Consultation Response from: KC Environmental Health (Pollution & Noise Control)		
2026/91564 land off, Heaton Grange, Hanging Heaton, Batley, WF17 6EN		
Erection of 21 dwellings		
Date Responded: 04/08/2026	Responding Officer: KB	Responding Ref: WK/202622873
Environmental Health have been consulted on the planning application for land at Hanging Heaton for the development of 21 dwellings. The site has been subject to an outline planning application 2020/93777 (East of Mill Lane and Heaton Grange, Hanging Heaton) and several of the reports were reviewed as part of discharging conditions relating to that previous permission which was for 19 dwellings with associated gardens. This application 2026/91564 has been treated as a new application for 21 dwellings and the reports submitted in support of the application have been reviewed subject to current guidance and best practice. <u>Contaminated Land</u> This site has been identified on the Council contaminated land database as “potentially contaminated land” (site reference 27/6) due to its historic land use including a gas works, landfill site, waste transfer stations and scrapyards. Several reports have been submitted in support of th

3B4P Plots
15-16 & 17-18

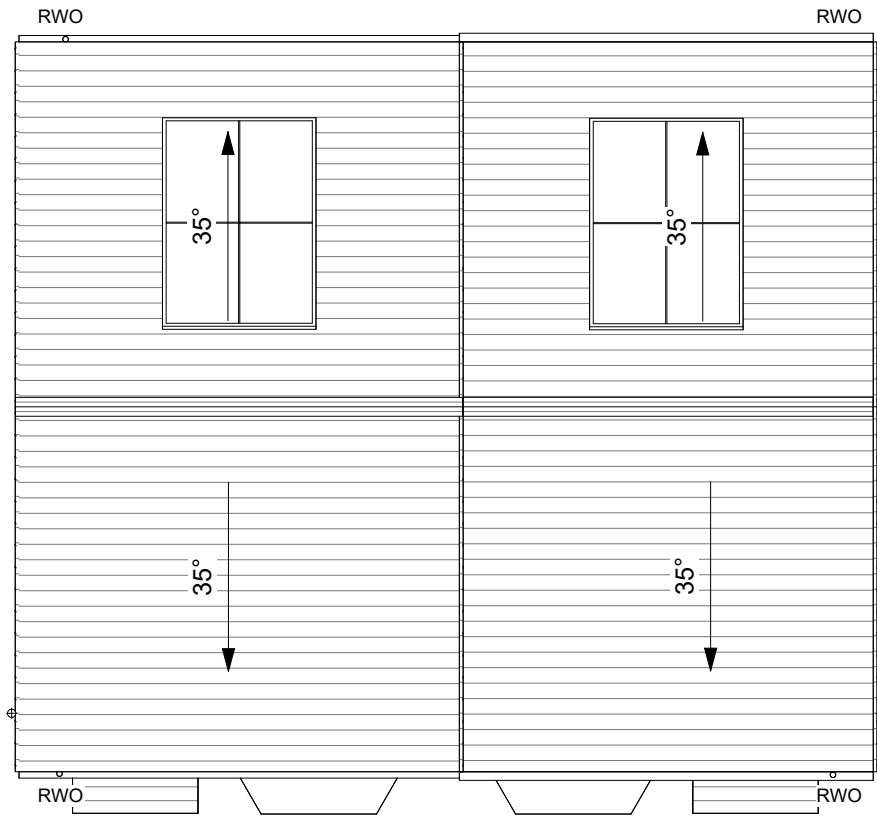
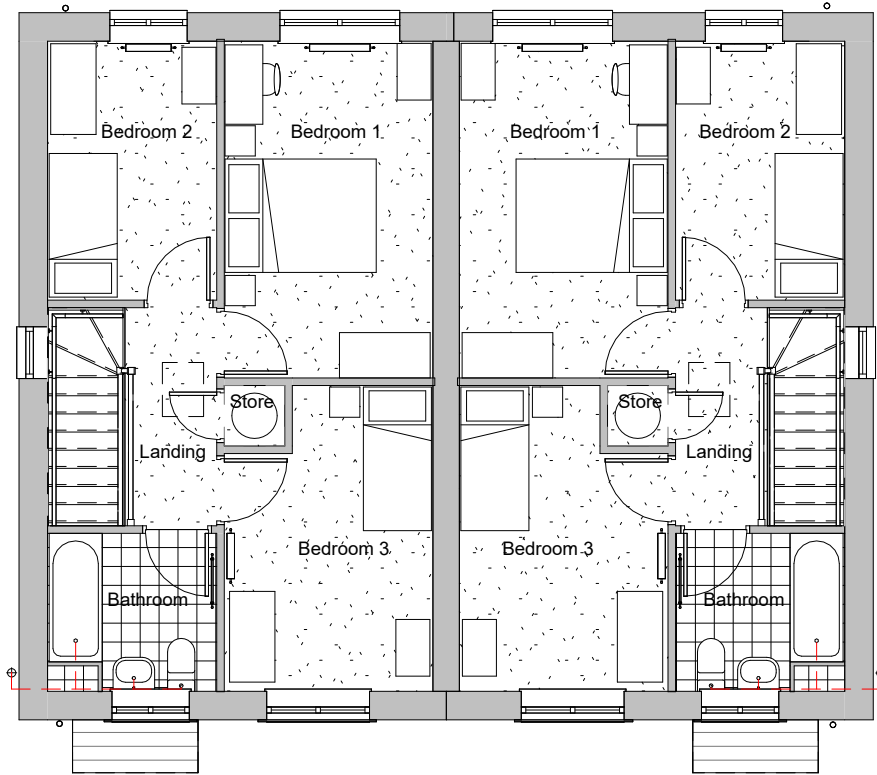
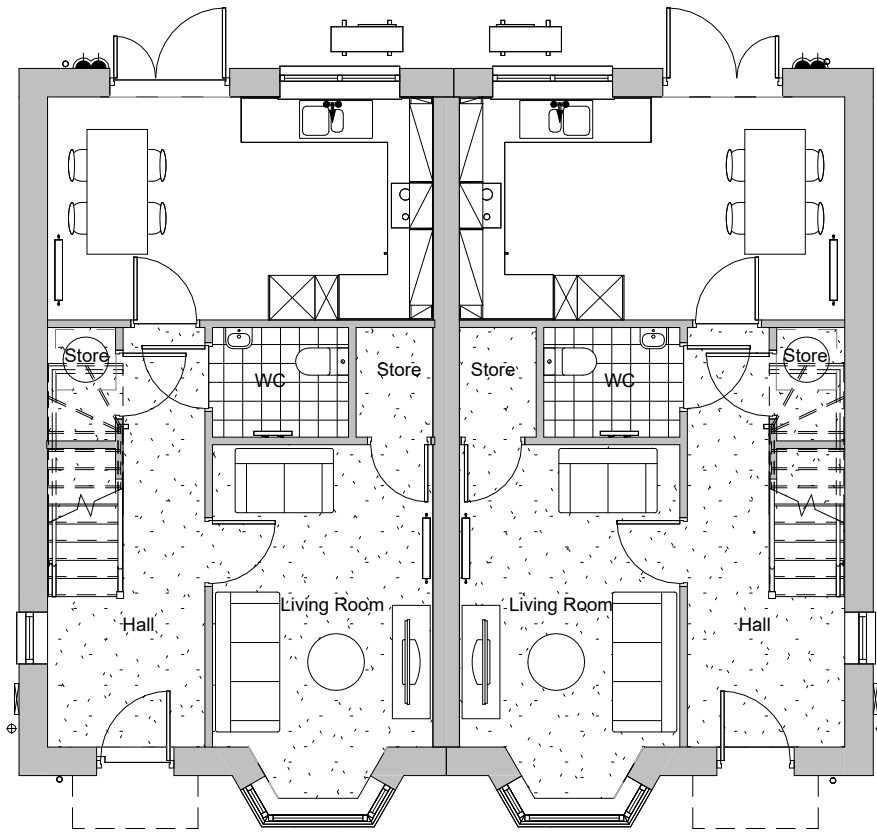
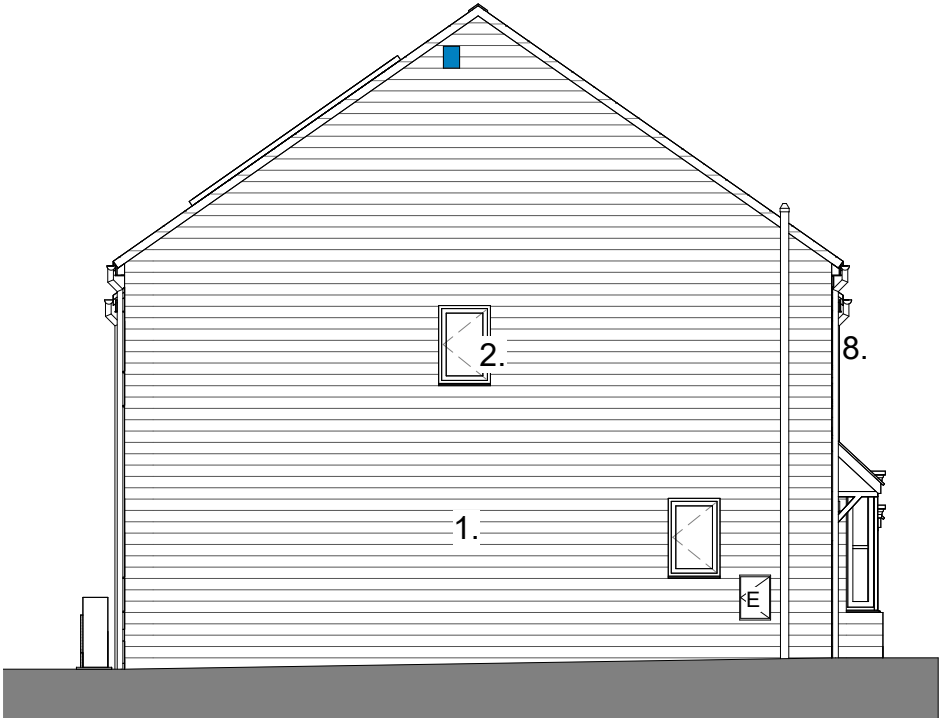
To meet with the external requirements of BS8233, a 2.4m high acoustic barrier is recommended to plots 10-18. No specific noise mitigation measures are required to the remaining plots.

Before the development is first brought into use, all works which form part of the sound attenuation scheme as specified in the Noise Impact Assessment authored by Apex Acoustics dated 12 February 2026 Ref 11457.2 RevB:
